**Re: Objection to MP08\_0244 MOD 1 Modification Request for Mixed Used Development at 23-37 Lindfield Avenue and 11 Havilah Lane, Lindfield**

As a resident of Lindfield, I/we wish to lodge an objection against the proposed Modification of the subject development based on the following grounds:

1 SHADOW DIAGRAM - 21stDEC_9AM
5003 SCALE1 : 650

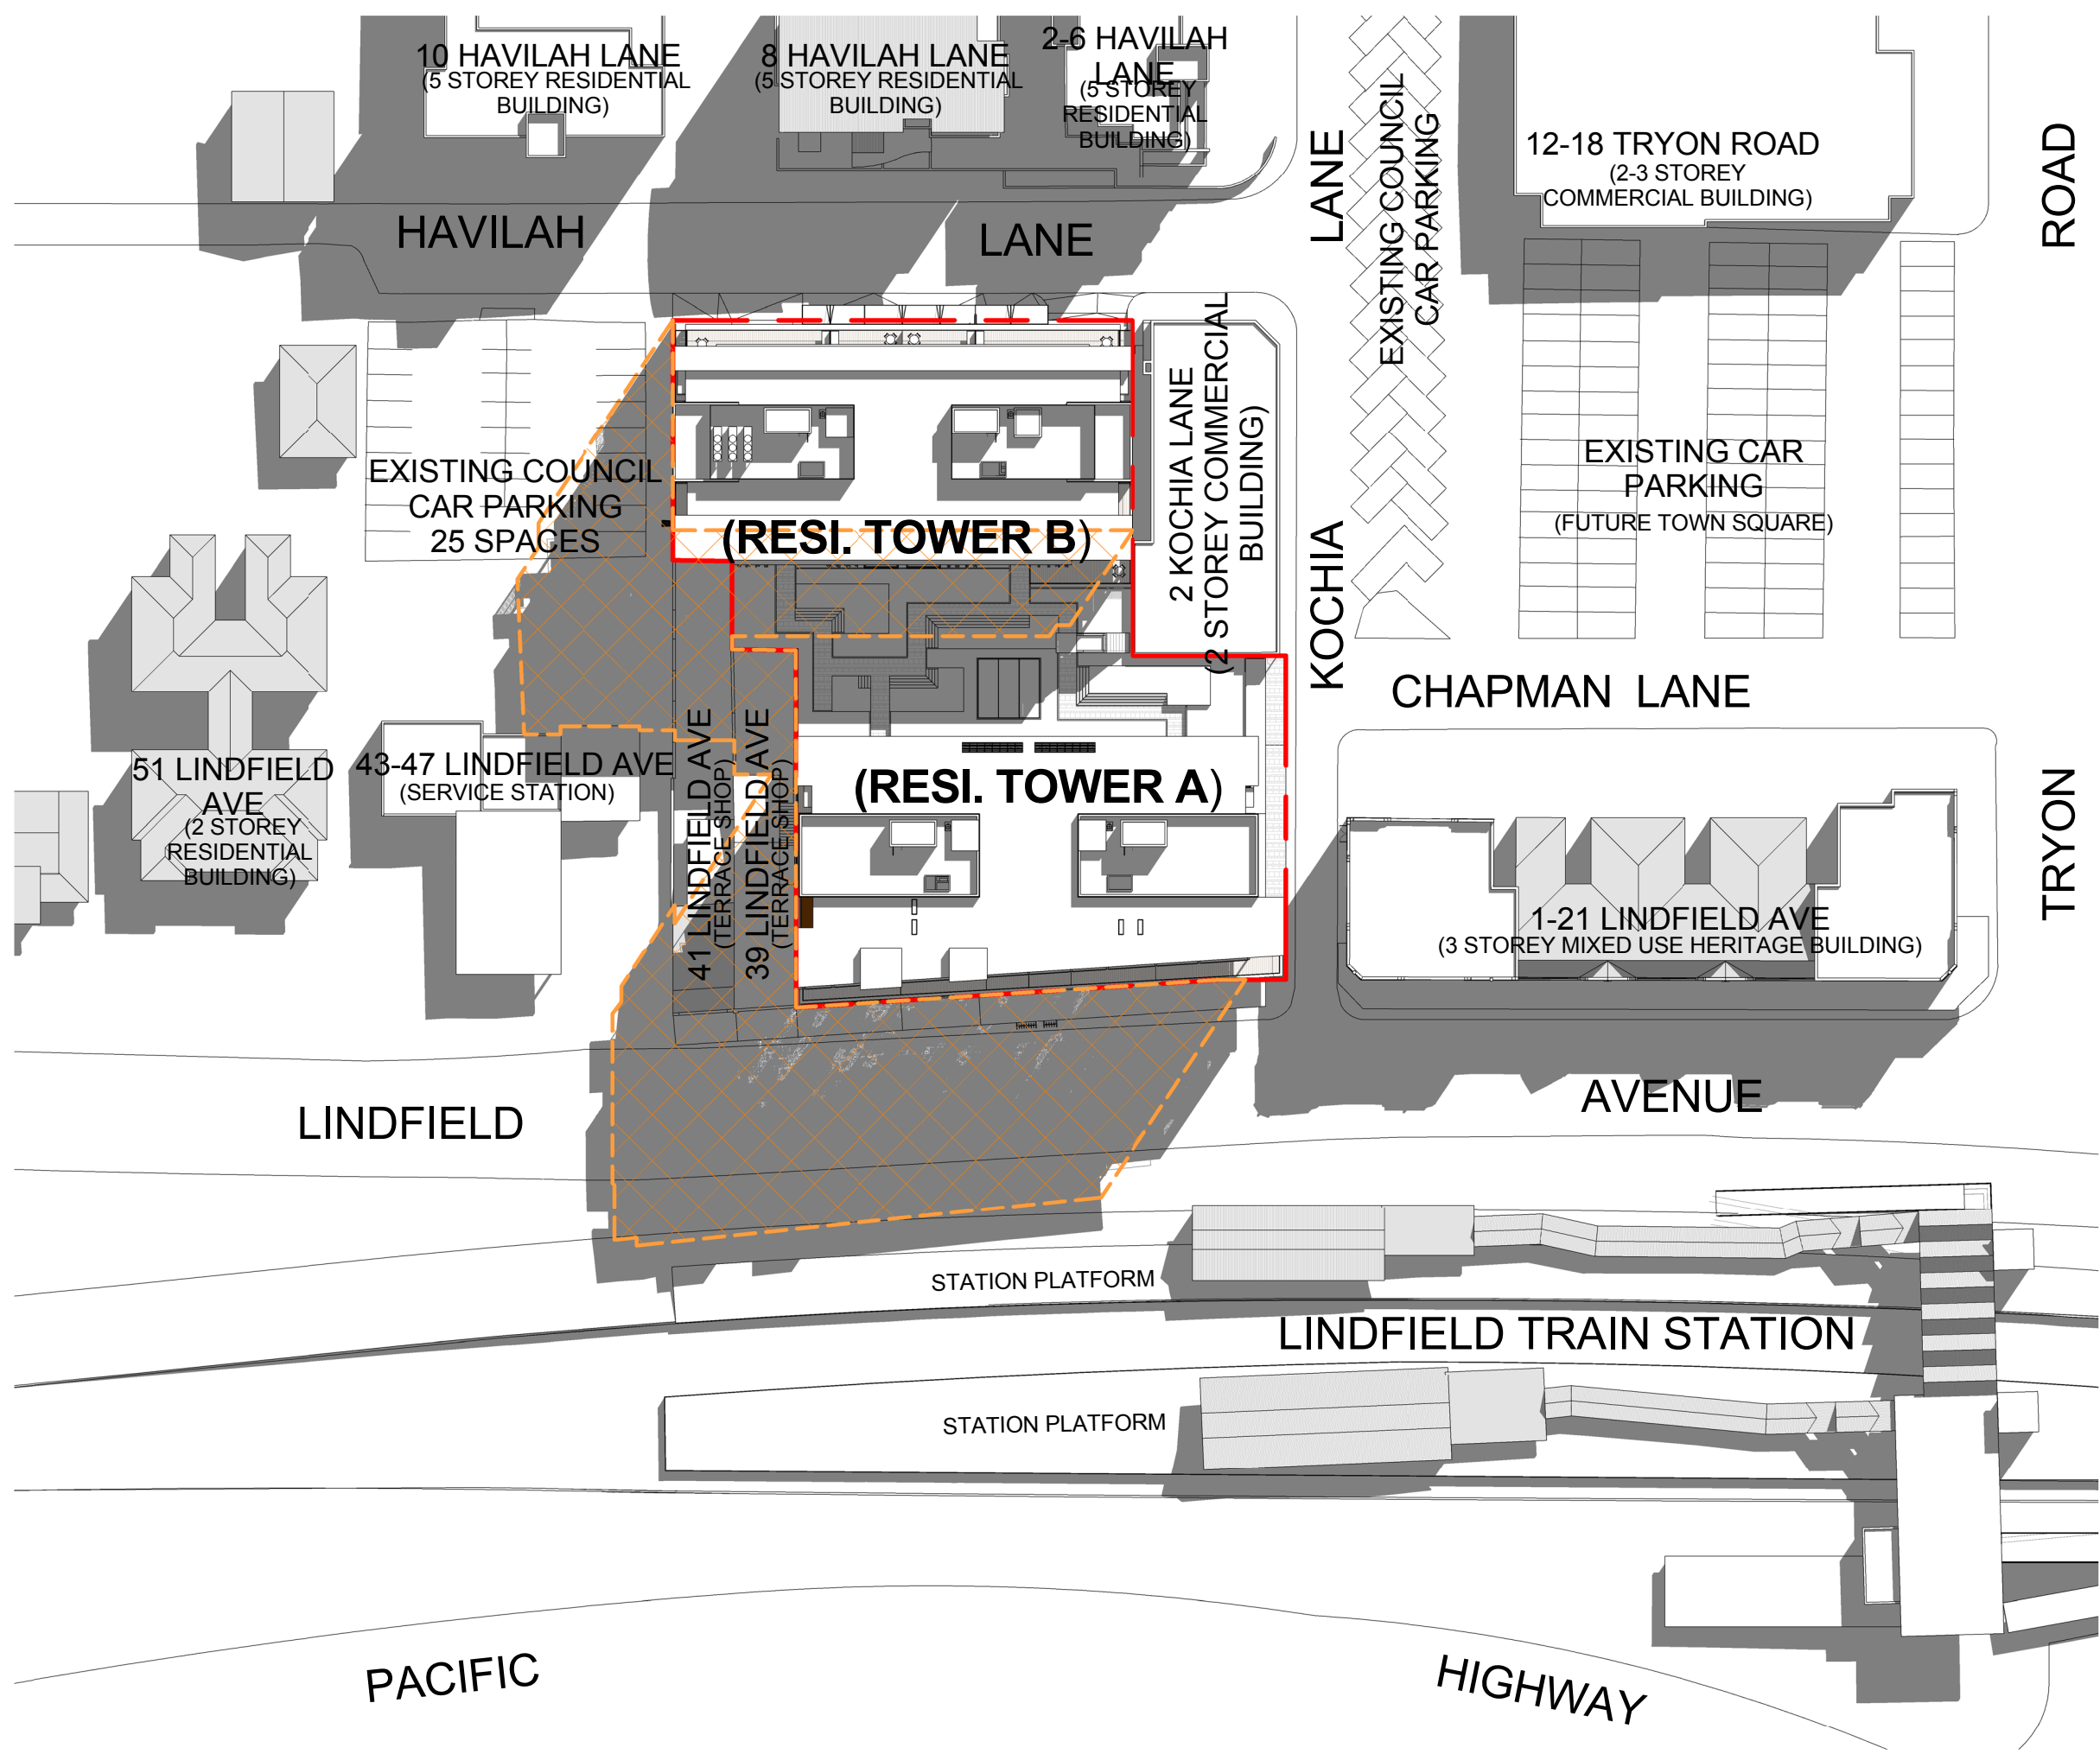
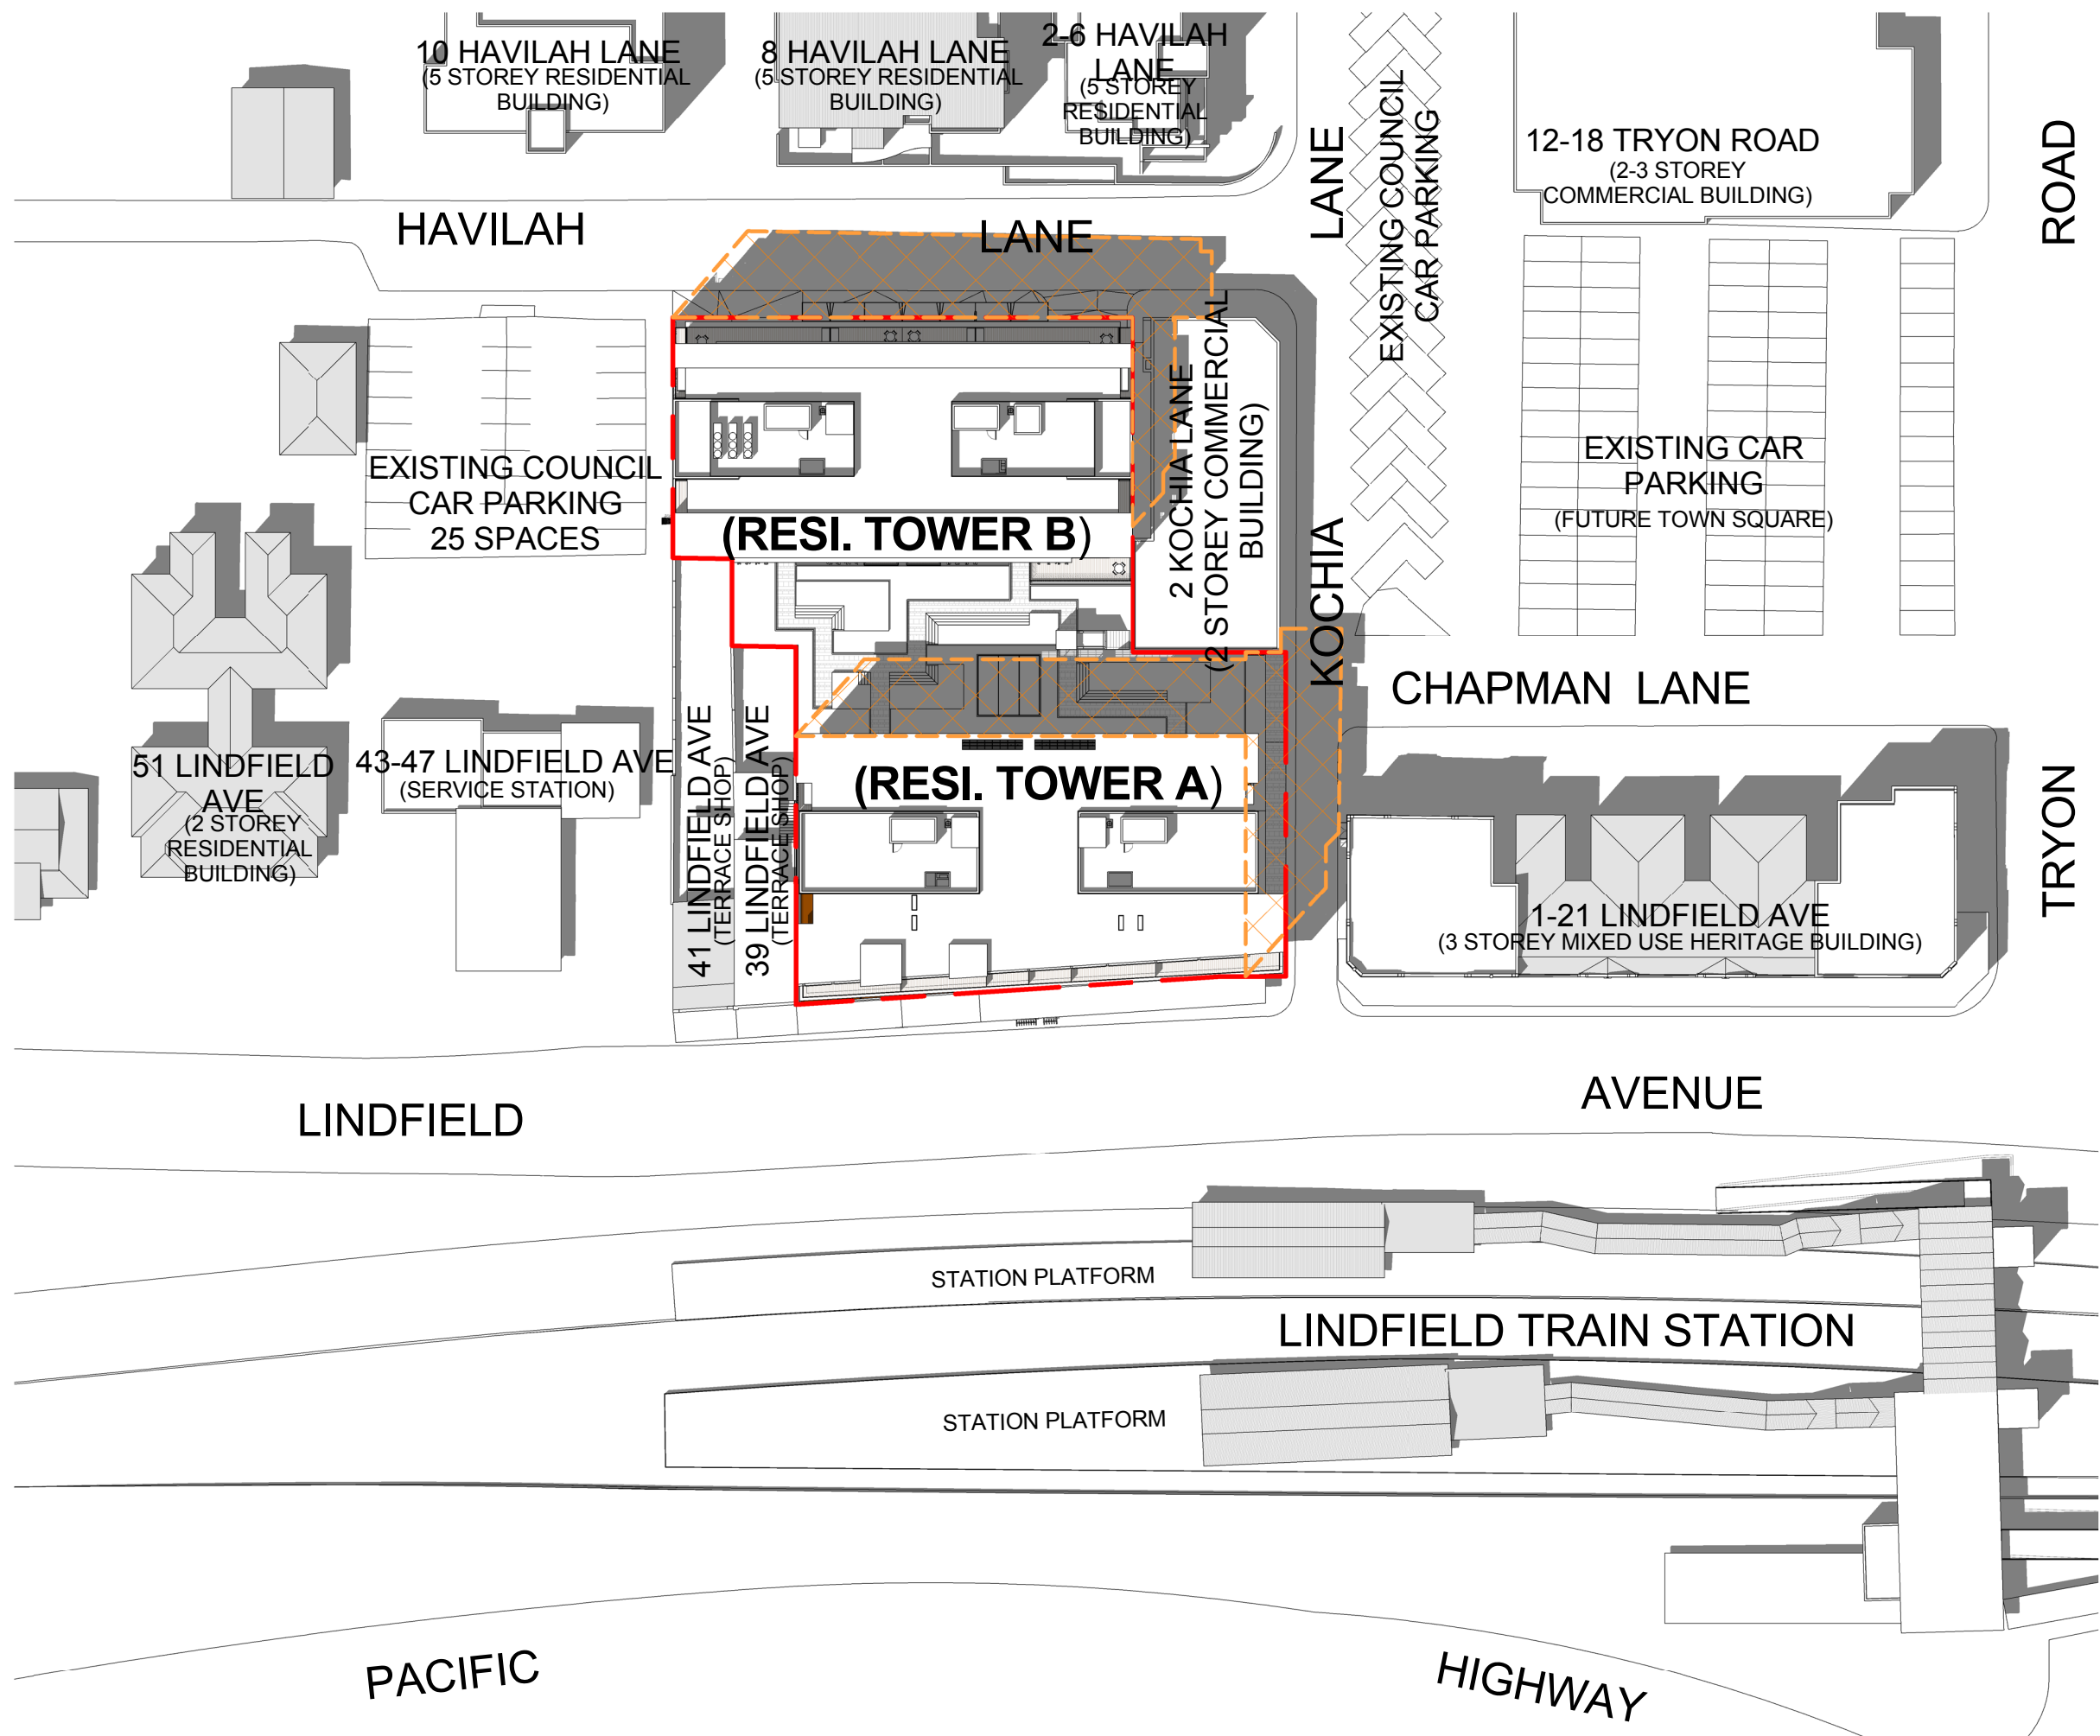
- The additional storeys create new adverse shadowing: a) for residents in the Havilah Lane apartments, particularly after 3pm b) for the popular outdoor café and central Lindfield hub area at 12 Tryon Road in afternoons, particularly in winter and c) for all commuters on the city bound Lindfield rail platform, instead of 50% of the year as approved, it will now be in shadow in the mornings 75% of the year
